Hornsea Project Three  
Offshore Wind Farm

Applicant's comments on Written Representations and  
Responses submitted by Interested Parties at Deadline 6

Date: 14<sup>th</sup> March 2019

Figure 4.2: Simplified Folk Sediment Classifications for each benthic grab sample location within the Hornsea Three benthic ecology study area.

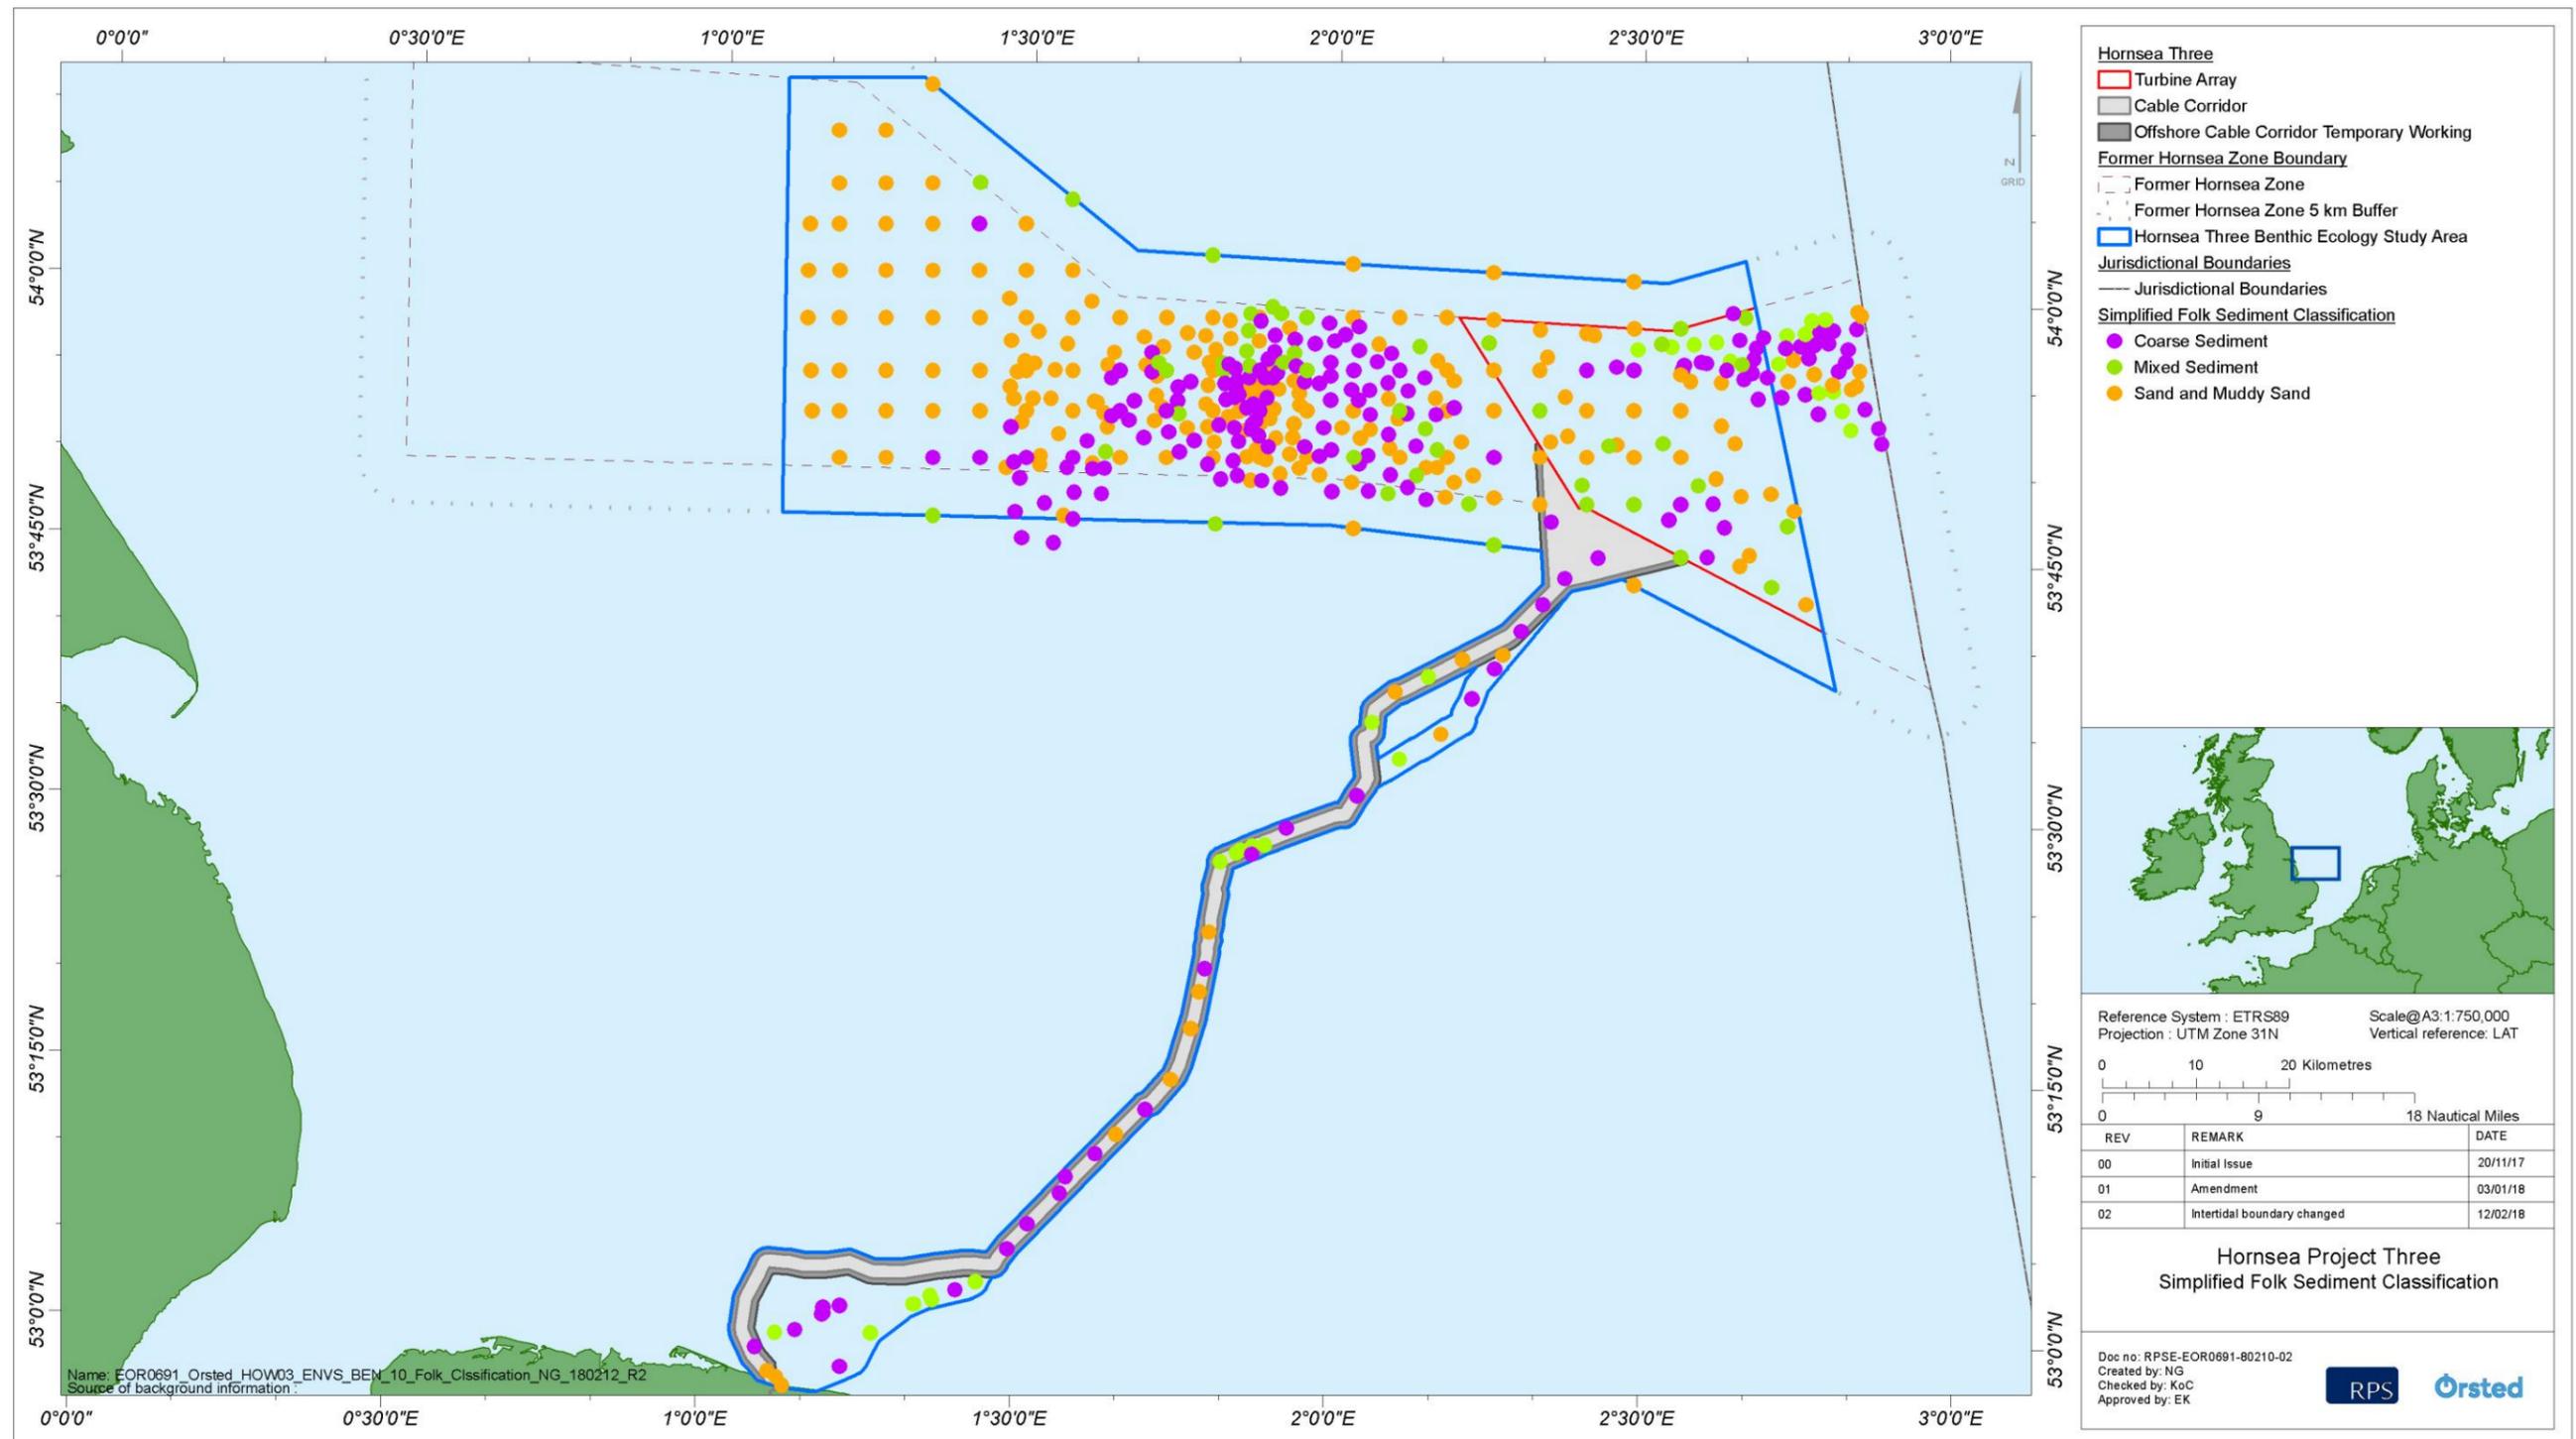
Interested Party Written Representation	Applicant's Response
	<p>Rough and Hornsea Project One) have been installed in the Bolders Bank Formation in recent years using these methods.</p>
<p>17. Figure 4.2: We are concerned about the consolidated mixed sediment/geogenic reef that we saw on the DDV data within the NNS SAC (close to the Dalek arm). That area could potentially be a more difficult area to install cables and one where rock armouring would be a concern.</p>	<p>The Applicant would note that while mixed sediments were recorded in the north of the NNSSR SAC, this was not classified as Annex I stony reef. Should Annex I reefs be identified during pre-construction surveys, direct impacts on these will be avoided, although based on current evidence, no such features were recorded.</p> <p>With respect to the ability to install cables in coarse sediments, see the Applicant's response to point 10 above. The Applicant is therefore confident that the presence of coarse sediments will not pose a significant challenge to cable installation.</p> <p>The Applicant would note that seabed imagery data (e.g. DDV) are used for the benthic ecology characterisation (i.e. they describe the habitats/communities present on the seabed), but these data are of little use in informing the ground model. The reason for this is that seabed imagery data only provide information on the surface sediments, rather than the subsurface geology, which is provided by geophysical and geotechnical datasets, as described in the Preliminary Trenching Assessment (see the Applicant's response to point 45 of NE's Written Submission of ISH5 – Offshore Ecology above).</p>
